Recommendation Report for Lawful Development Certificate for a Proposed Use or Development

REF NO: FP/90/19/CLP

LOCATION: 58 Outerwyke Road
Felpham

PROPOSAL: Lawful development certificate for a proposed construction of 2 No. garden tidy units in the front garden.

SITE PLAN

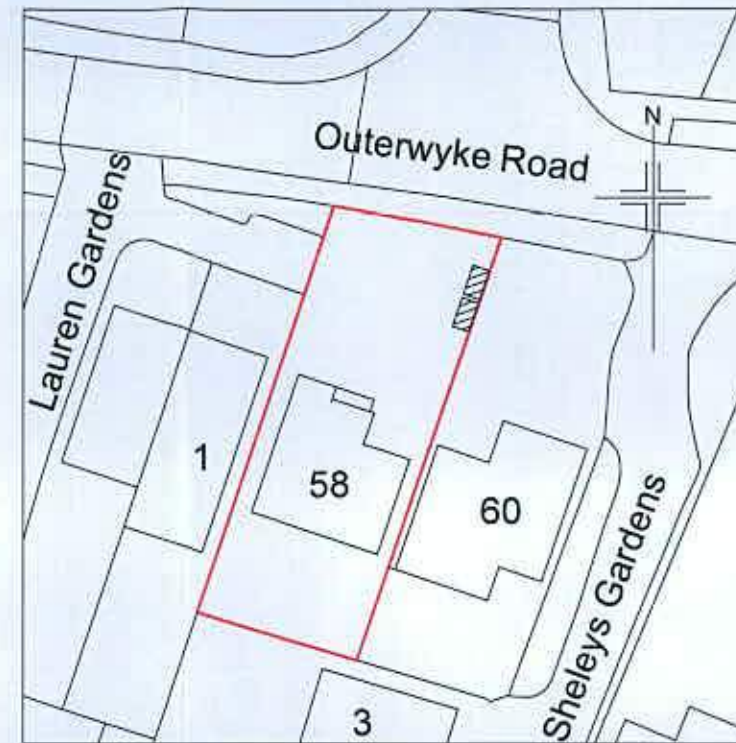
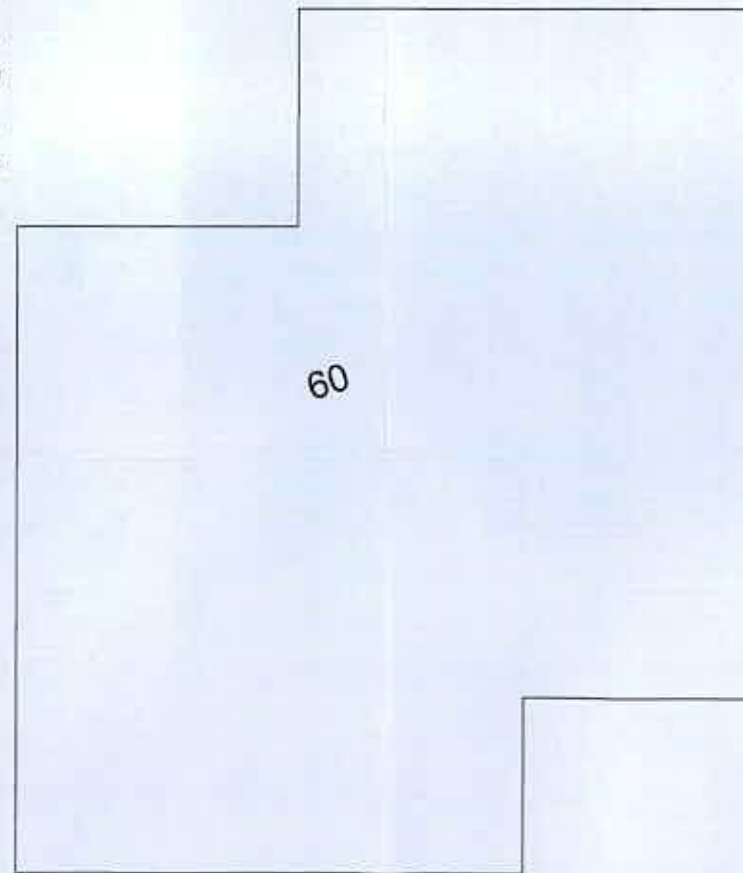
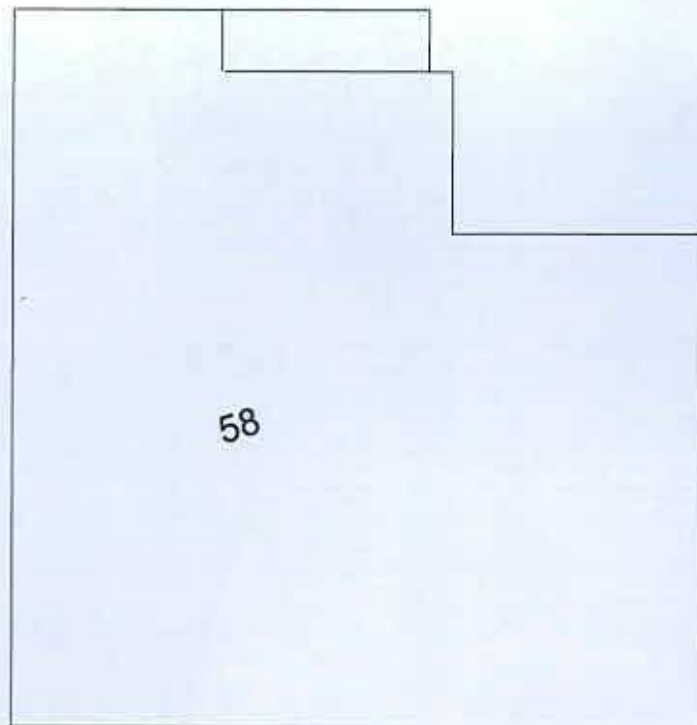
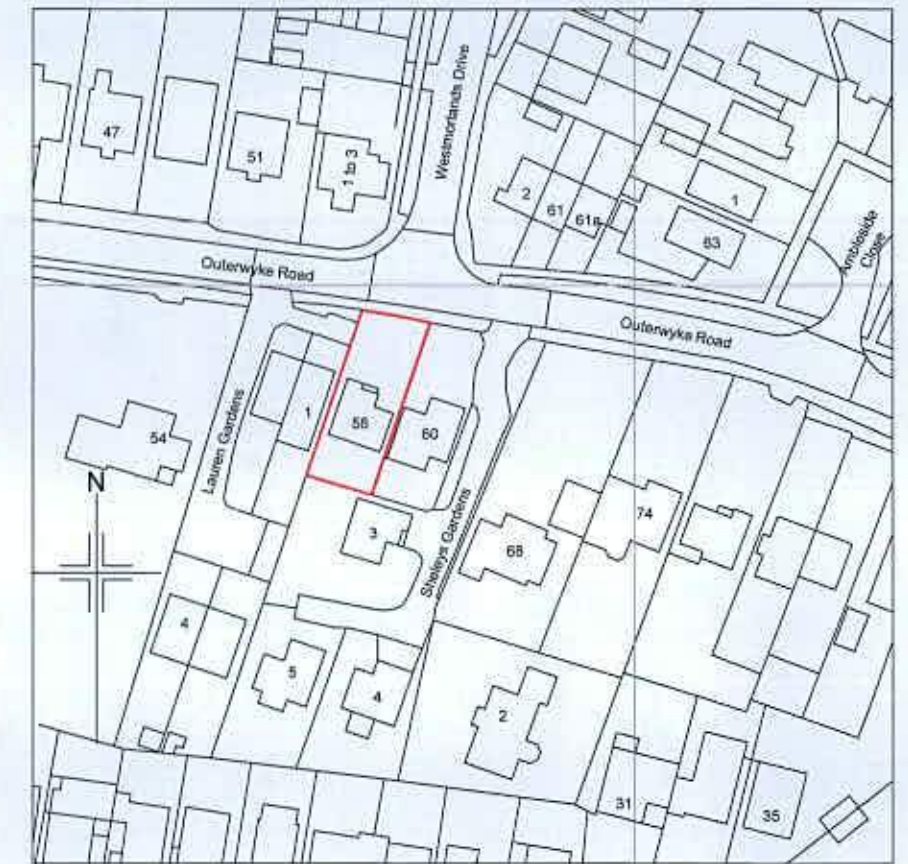
The proposed garden tidy units are considered to conflict with the limitations set out in Schedule 2 Part 1, Class E (c) of the Town and Country Planning Permission (General Permitted Development Order) (England) Order 2015. The proposed garden tidy units are considered to be situated forward of a wall forming the principal elevation of the original dwellinghouse.

- The proposed development conflicts with Schedule 2, Part 1, Class E (C) of the Town and Country (General Permitted Development) (England) Order 2015. The proposed garden tidy units are considered to be situated forward of a wall forming the principal elevation of the original dwellinghouse.
